Planning Statement

20 Westholme Gardens, Ruislip, HA4 8QJ

This Planning Statement has been prepared in support of a householder planning application at 20 Westholme Gardens, Ruislip, HA4 8QJ.

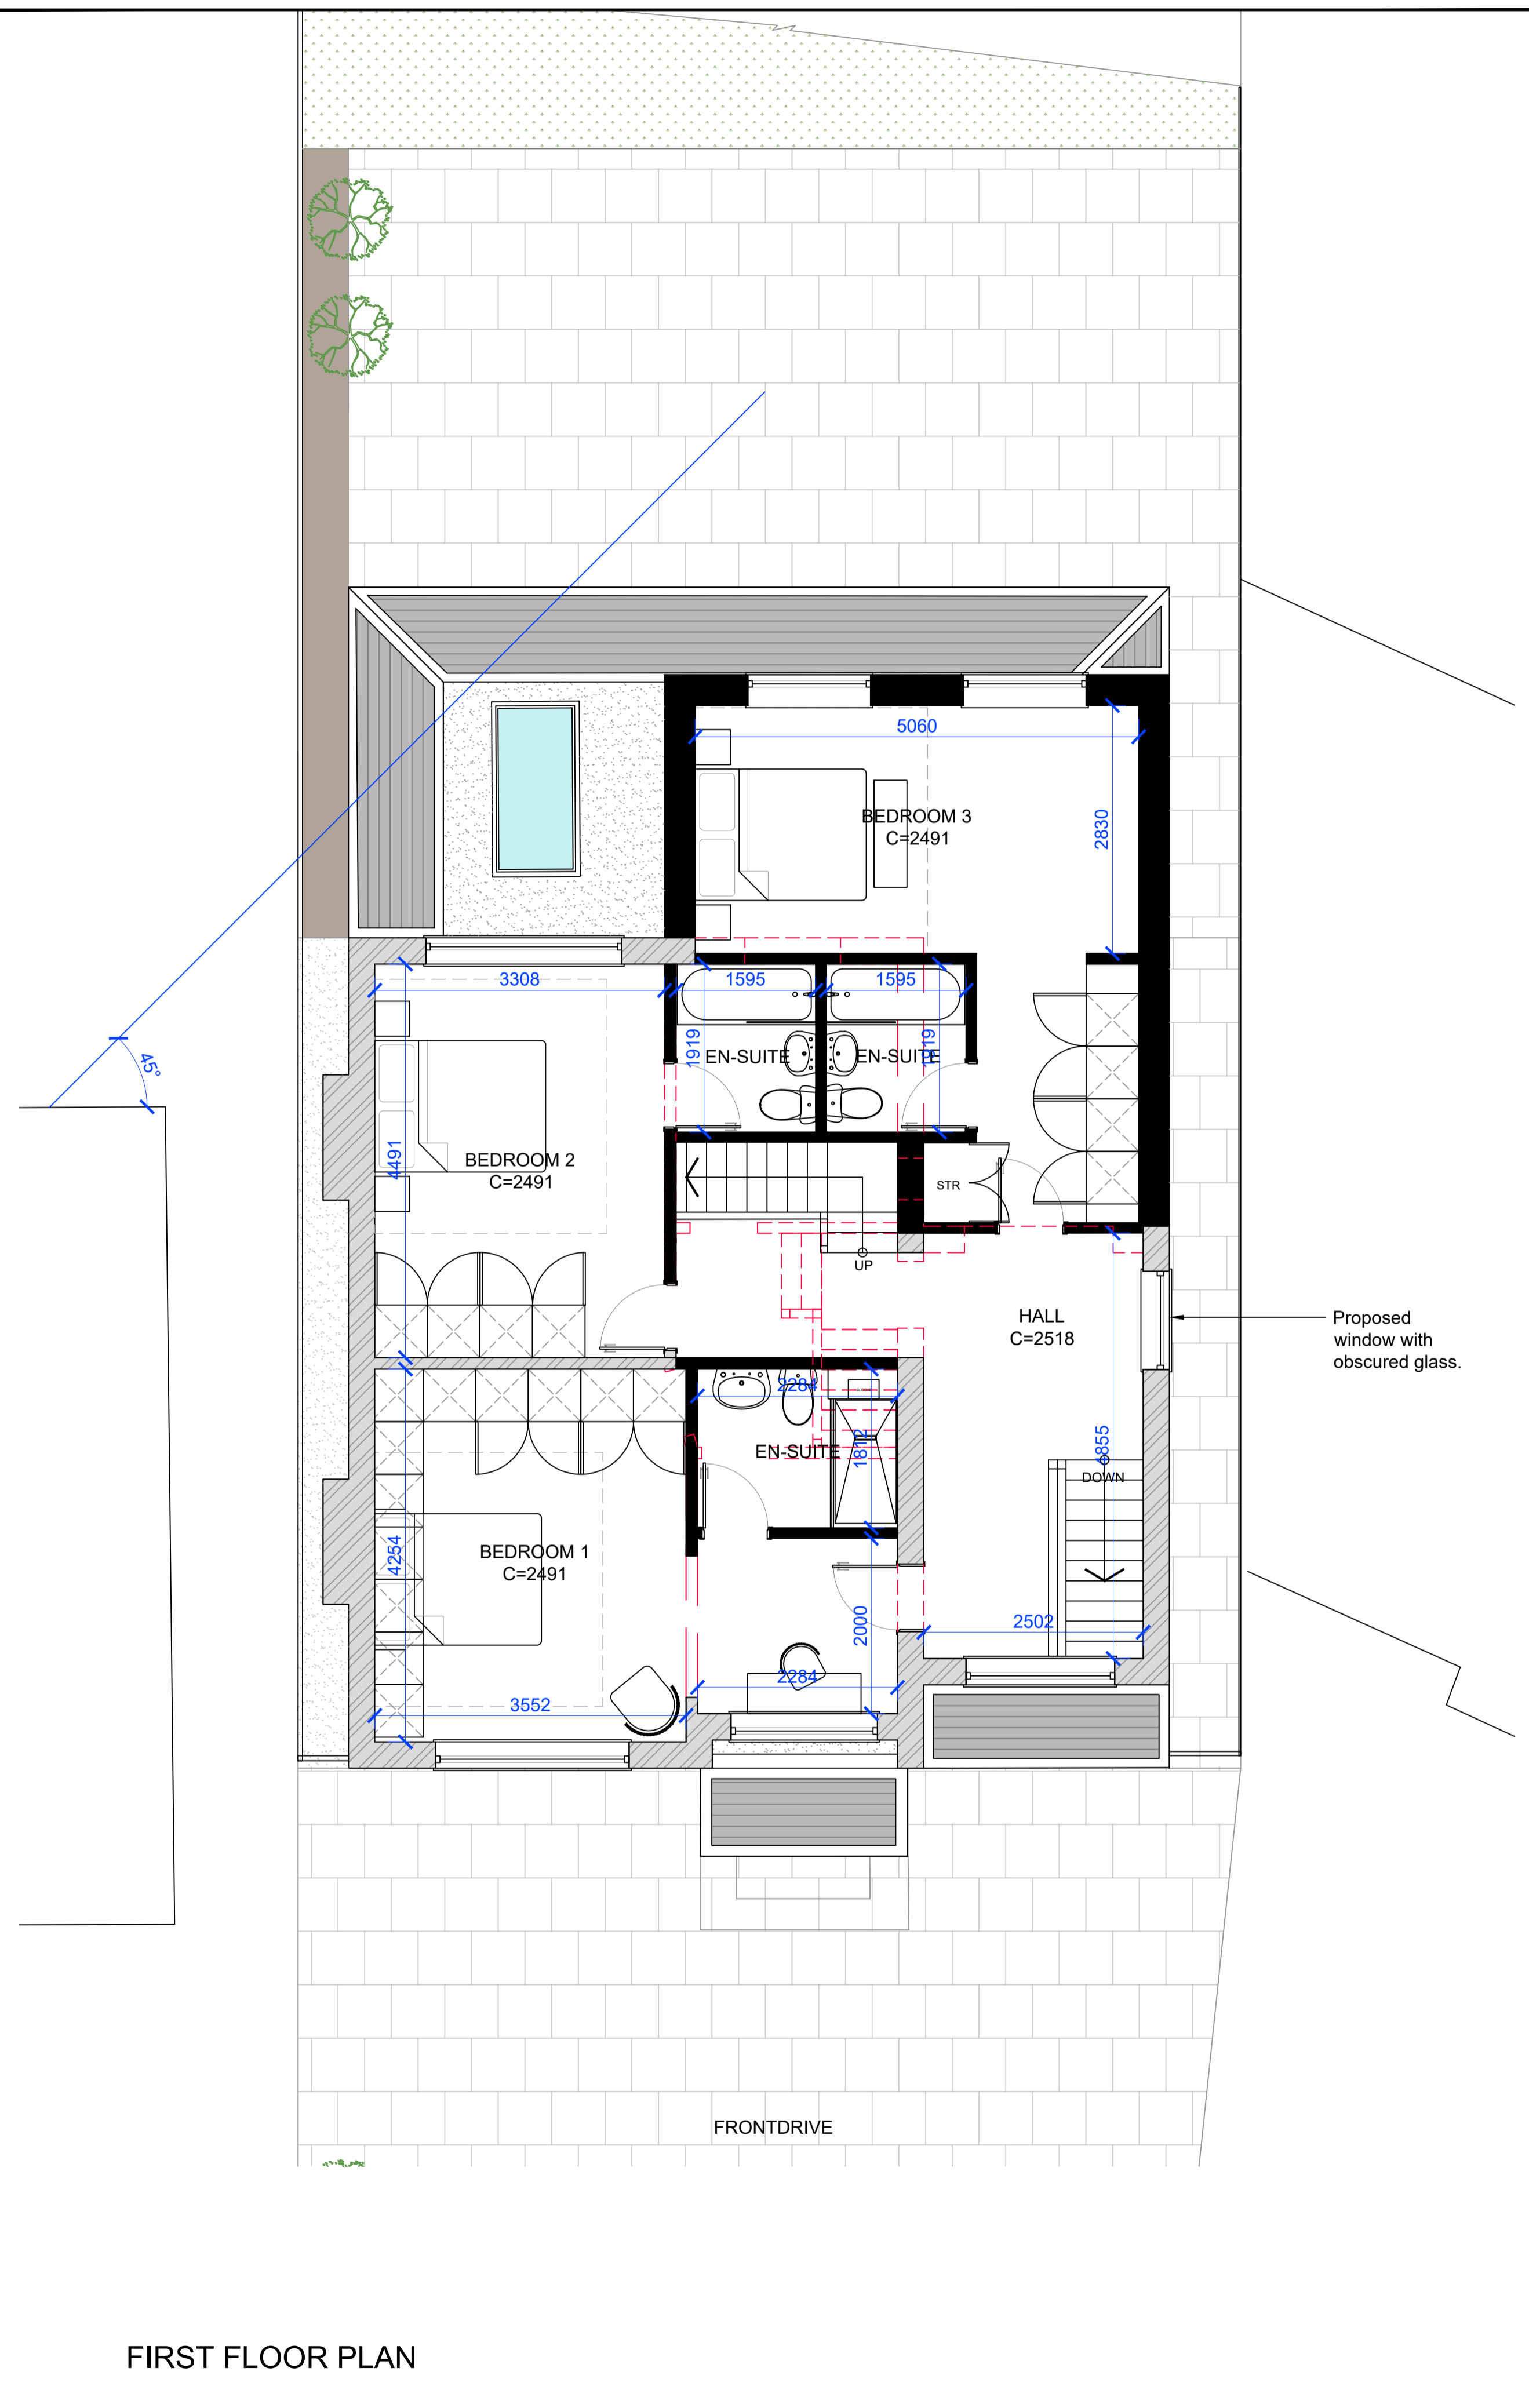
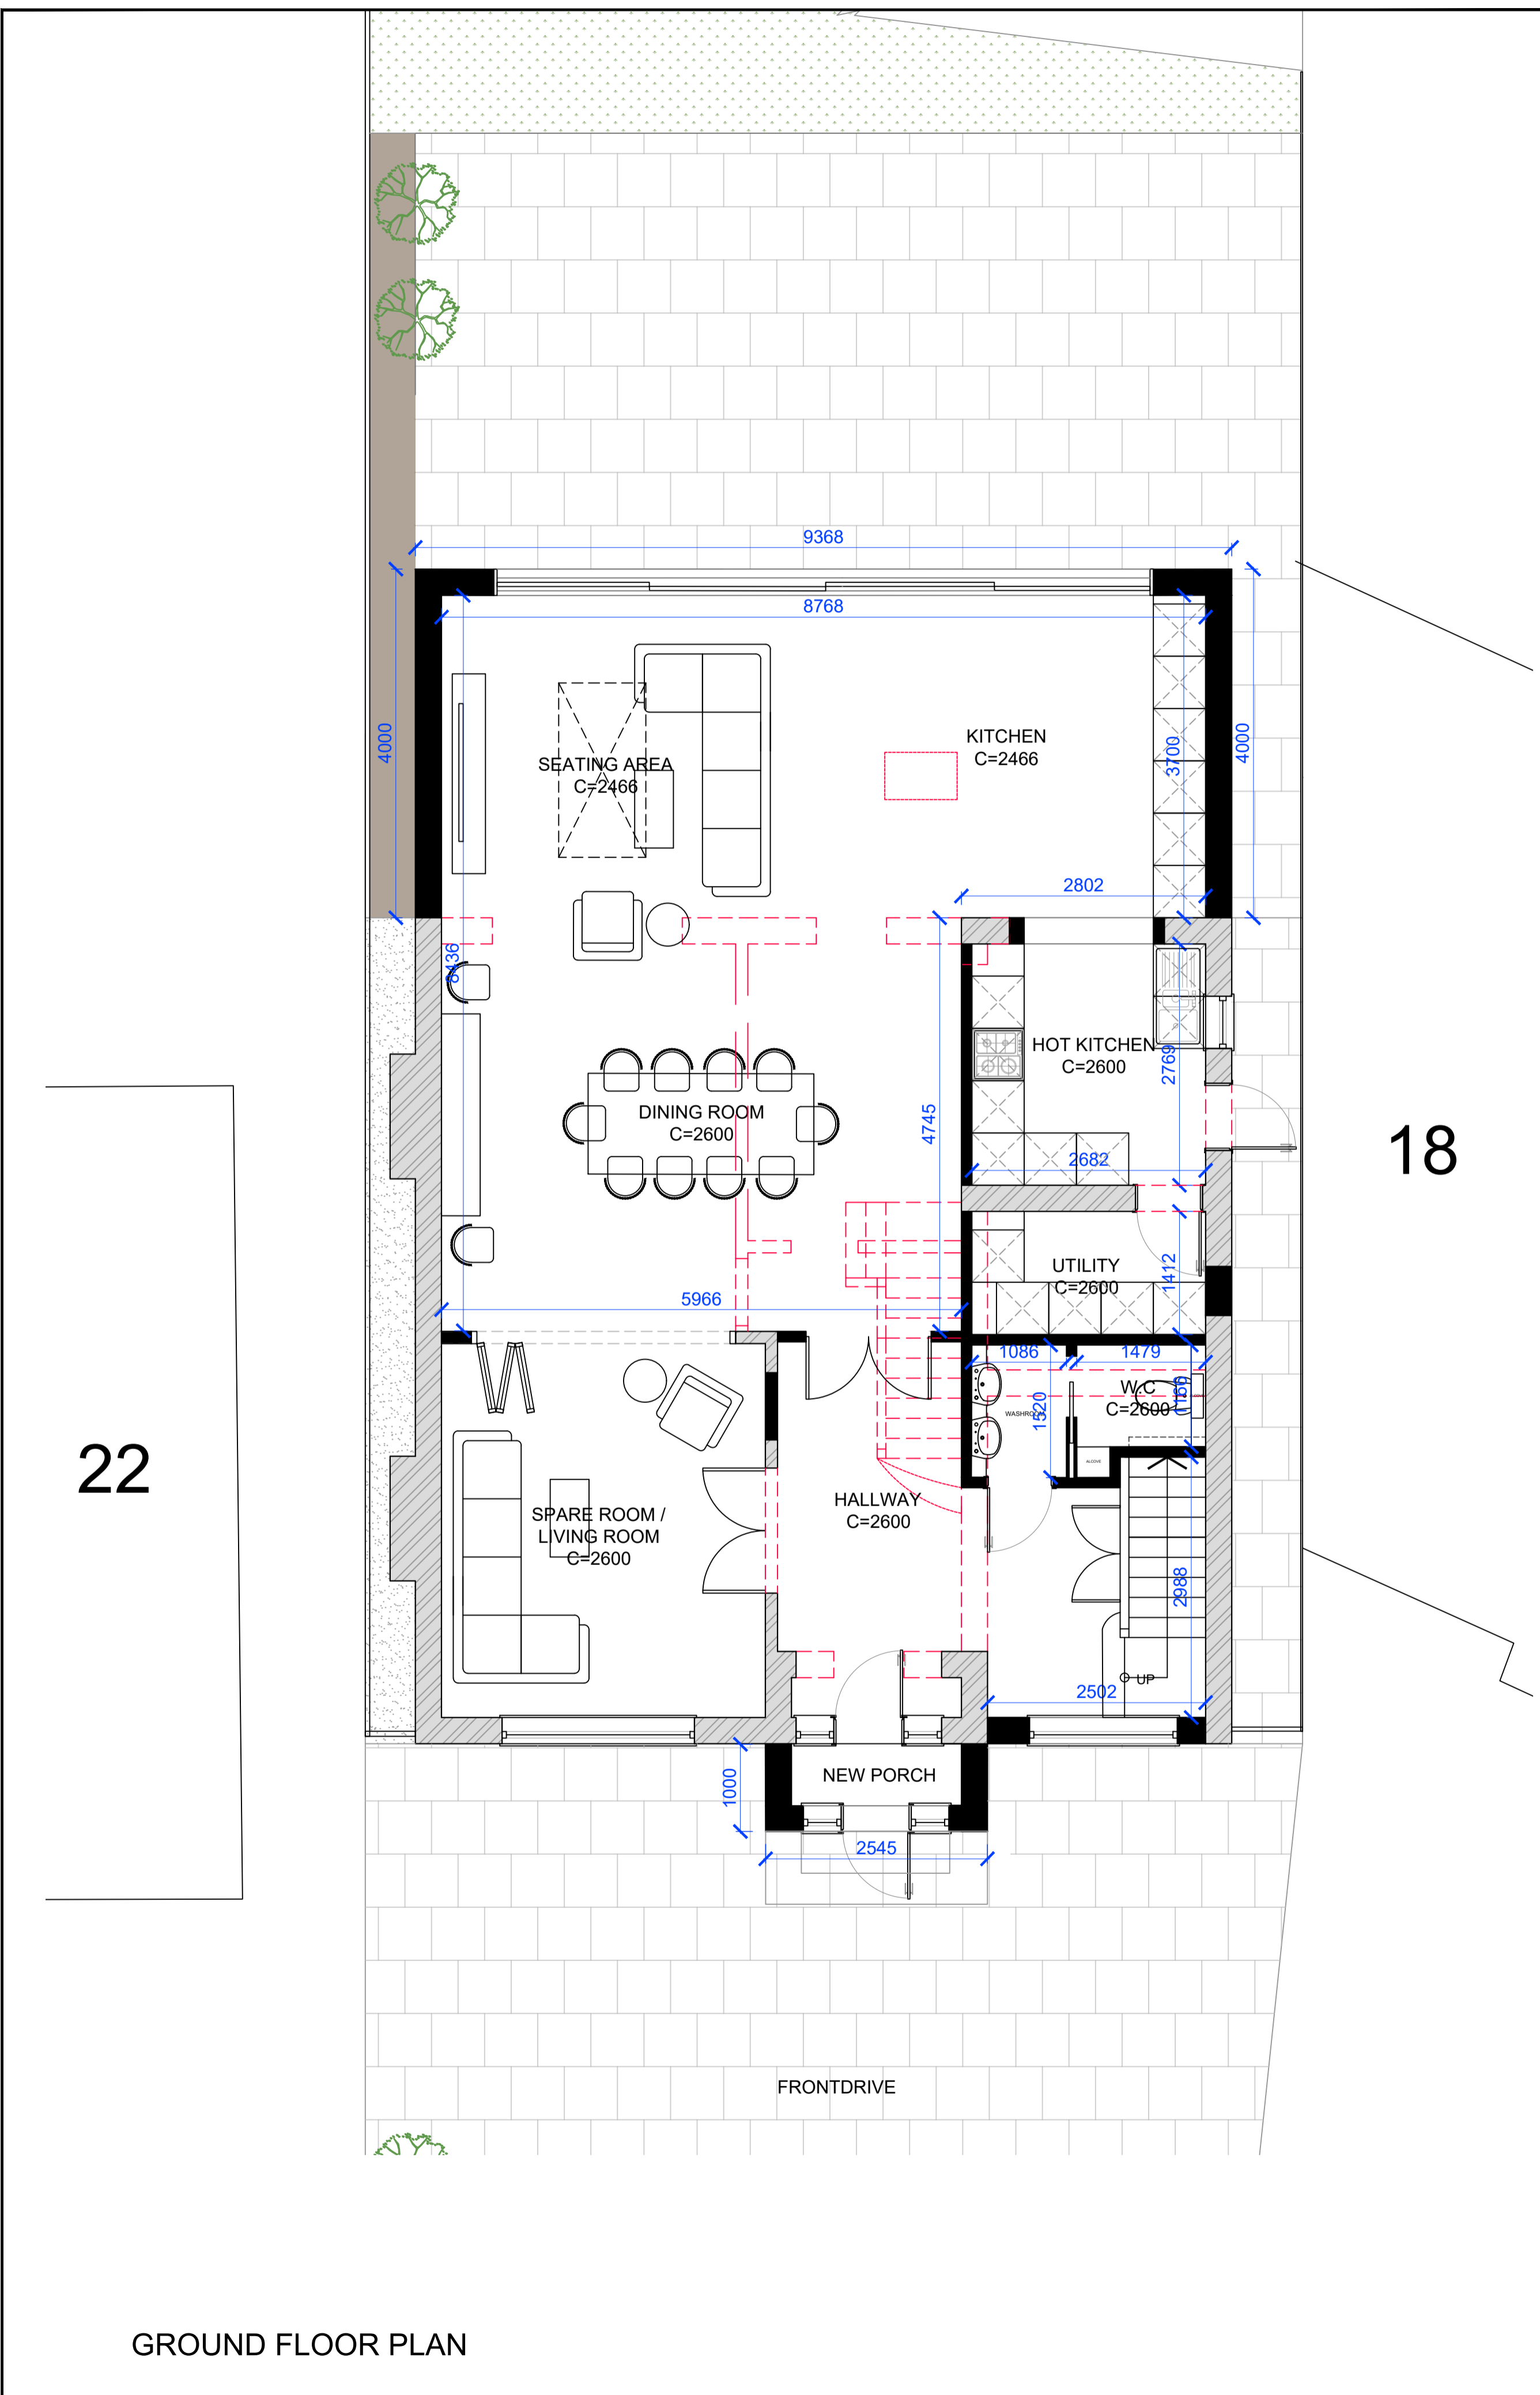
The pre-application scheme included a single-storey rear extension with a depth of approximately 6 metres and a height of approximately 3.47 metres. The Council advised that this should be reduced to a depth of 4 metres and a height of 3 metres to better accord with Policy DMHD 1.

The submitted proposal has been amended accordingly. The proposed floor plan and side elevation now show the rear extension reduced to a depth of 4 metres, with a reduced height to sit more comfortably with the host dwelling and neighbouring properties. This directly addresses the officer's concern regarding the scale of the rear projection.

ROOF PLAN

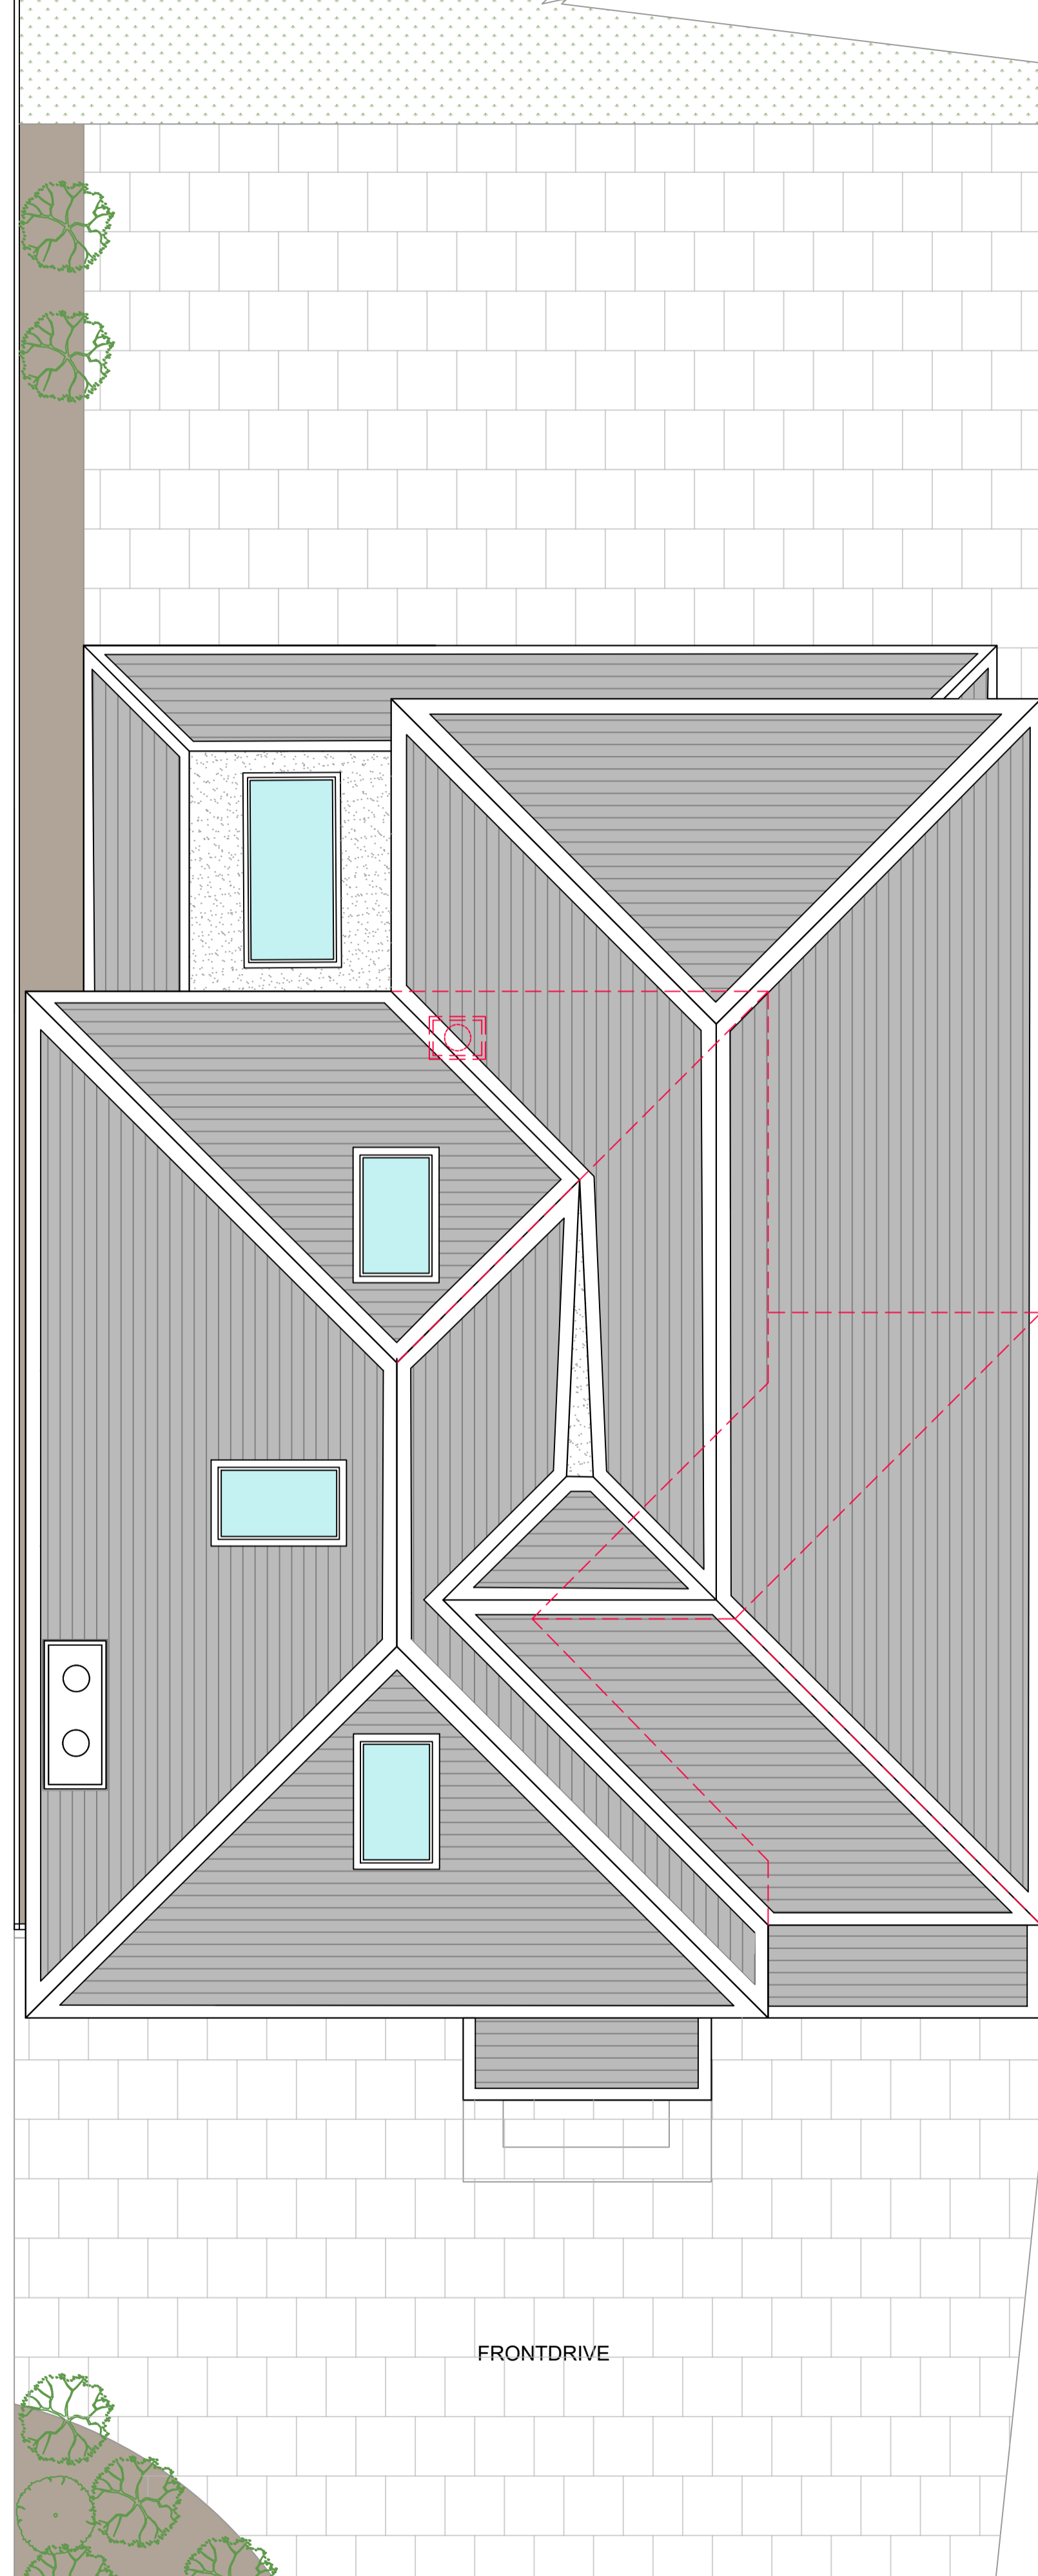
The pre-application advice raised concerns that the previous rear dormer visually clashed with the pitched roof form of the proposed two-storey rear extension. It was also recommended that the side dormer should be set down from the ridge line to achieve a more subservient appearance.

The Council noted that large crown roofs on detached houses are generally not supported, while also acknowledging that there are examples of smaller crown roof forms within the locality and that there may be an on-balance argument for a modest, well-integrated crown roof within an amended proposal.

The submitted roof design has been revised to improve the relationship with the main roof form. The dormer arrangement have been removed to minimise any roof impacts.

The revised proposal has sought to ensure that the roof form is integrated with the host dwelling and surrounding context. The roof design has been amended so that a crown is not required.
